## **BCA ASSESSMENT REPORT**

### **Oakdale East Estate, Kemps Creek Brickworks Warehouse 1 Extension**

**Prepared For:  
Goodman Property Services Pty Ltd**

Date: 13 April 2022

Precinct 1 - Site &
Warehouse Plan

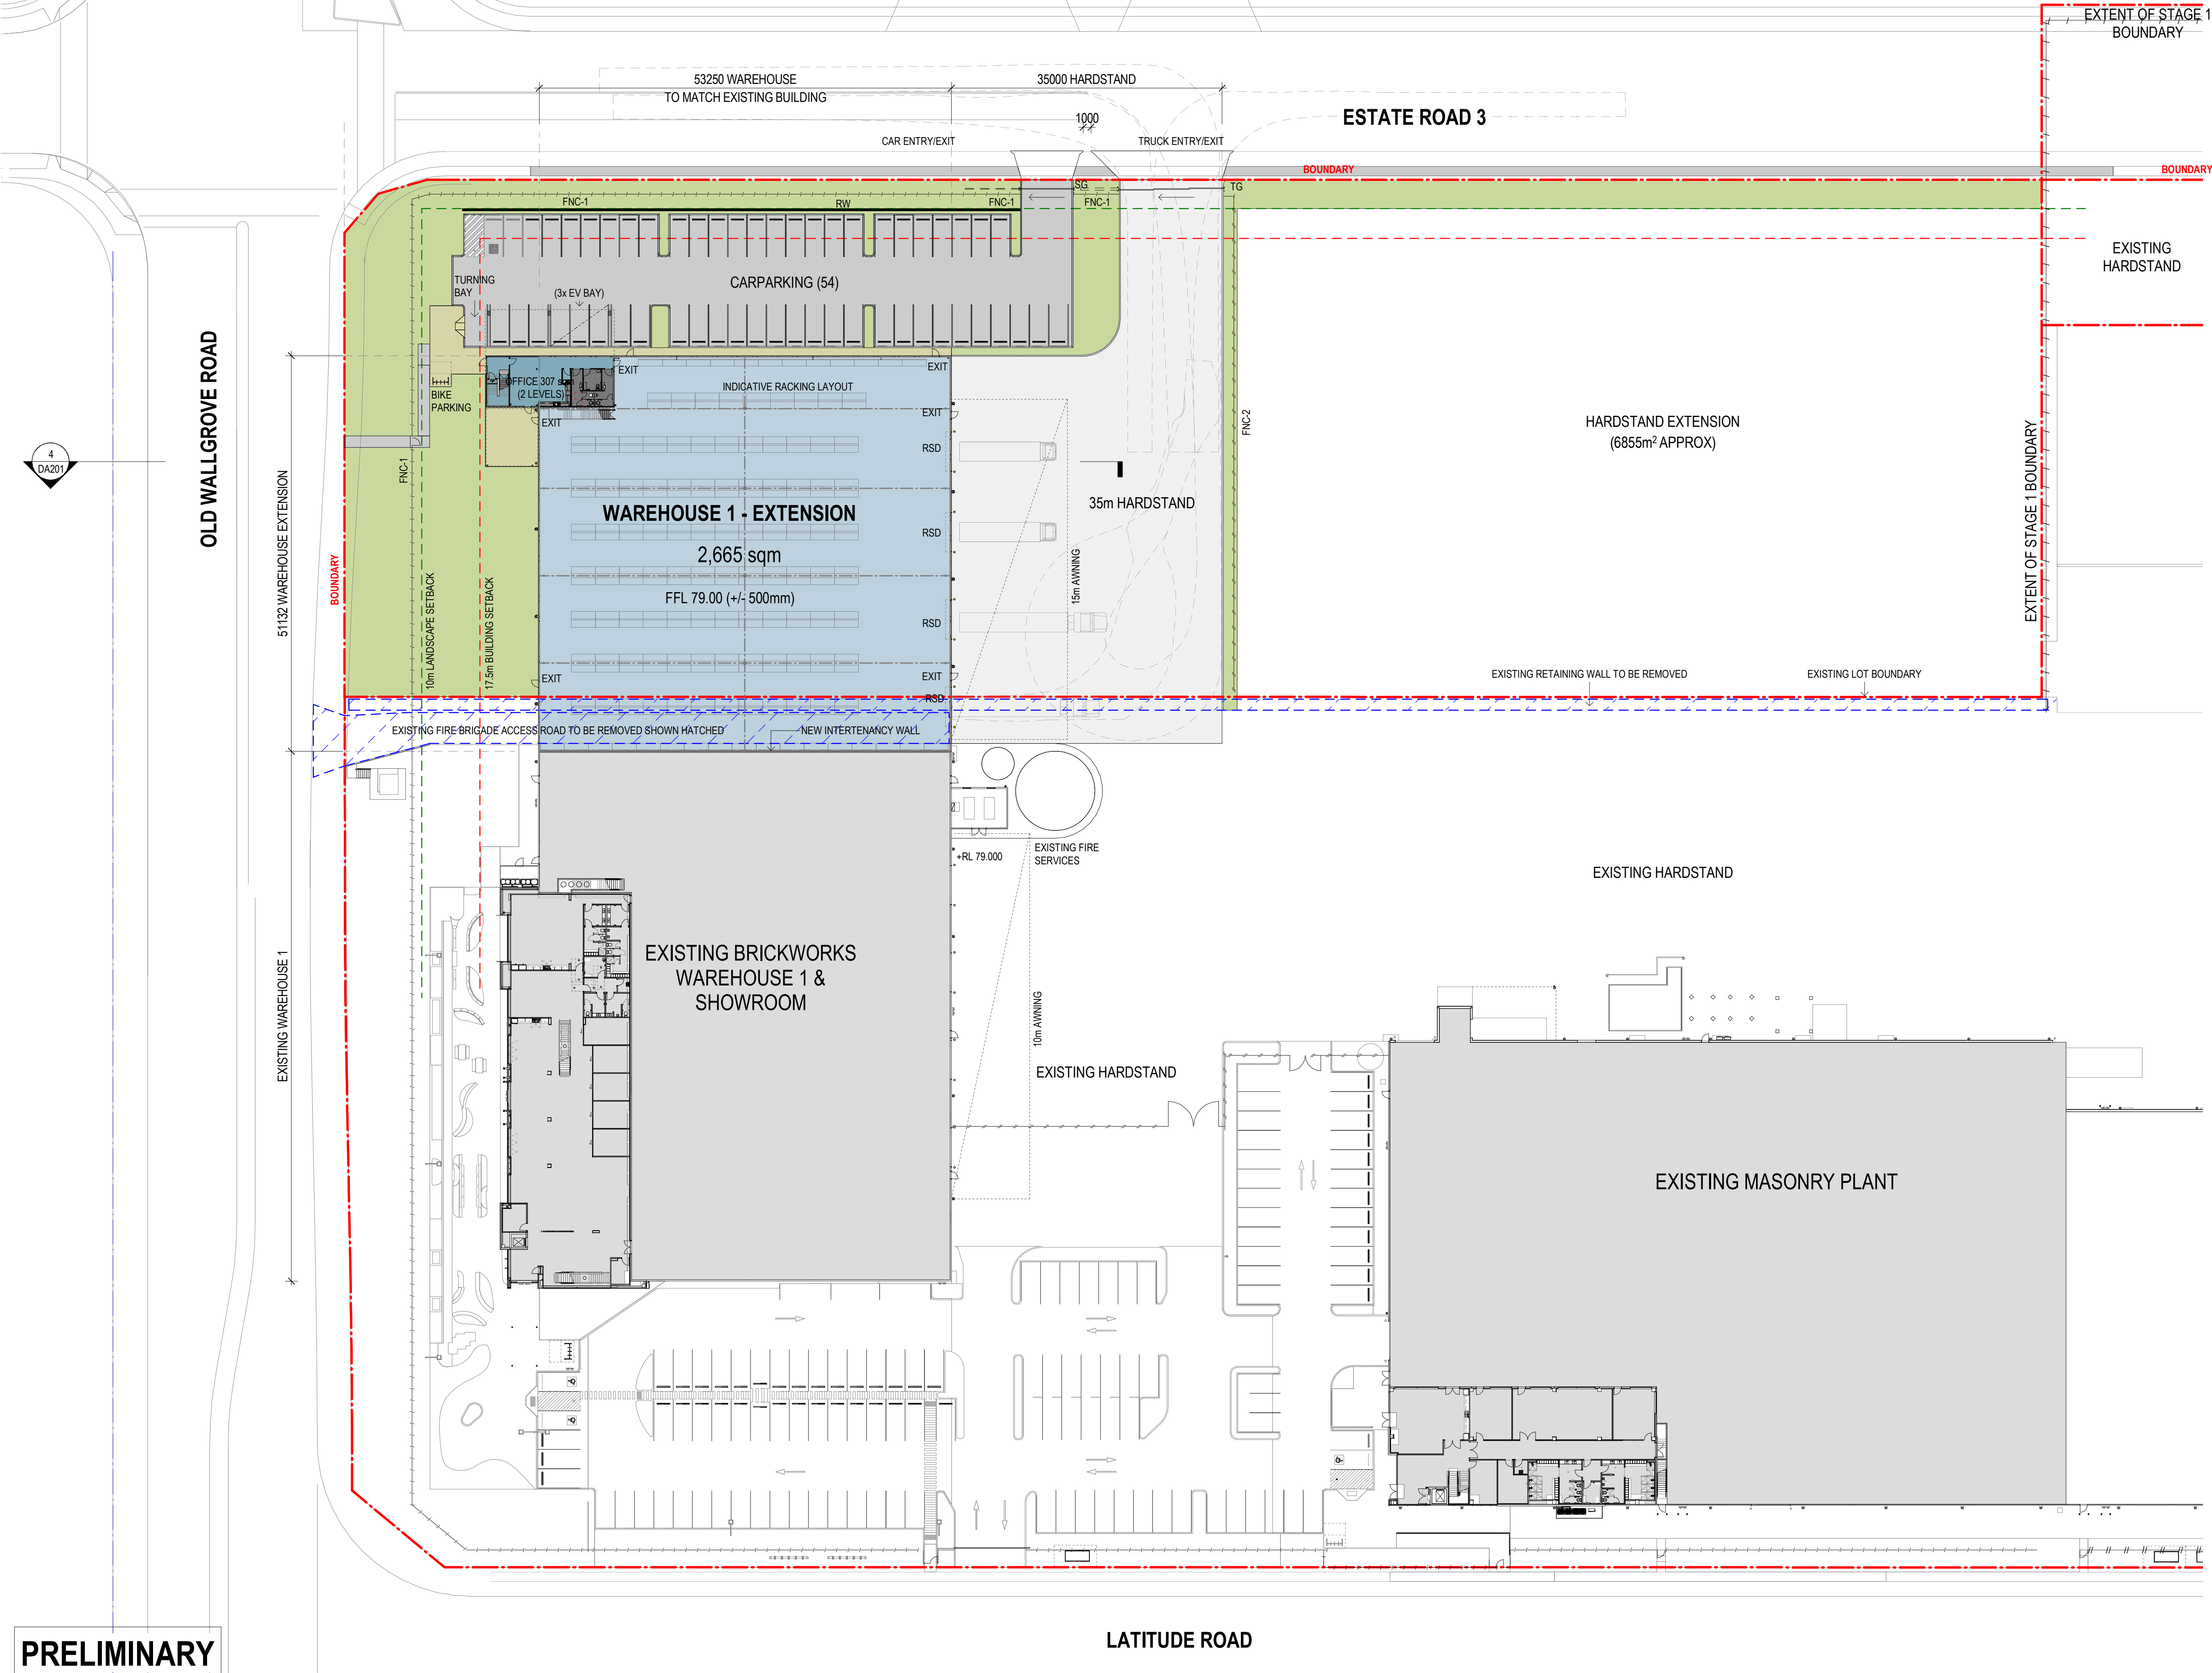
*Comments: The existing warehouse building is subject to a Performance Solution for perimeter vehicular access being greater than 18m from the external walls of the Southern and Western perimeters and perimeter vehicular access being less than 6m on the Northern end of the building (as documented in the Core FER). The following non-compliances have been identified as a result of the proposed warehouse extension and will be required to be addressed / updated in the Fire Engineering Report:*

- *The furthest part of the vehicular access path is greater than 18m from the external wall at the Northern and Western ends of the building along Estate Road 3 and Old Wallgrove Road respectively.*

- The furthest part of the vehicular access path is greater than 18m from the external wall at the Southern and South Eastern ends of the building along Latitude Road and the carpark between Warehouse 1 and the Masonry plant respectively.

*Comments: The exit travel distances in the proposed extension part are non-compliant with the requirements of Clause D1.4 as detailed below:*

- Up to 43m to the nearest exits from the Central parts of the Warehouse.
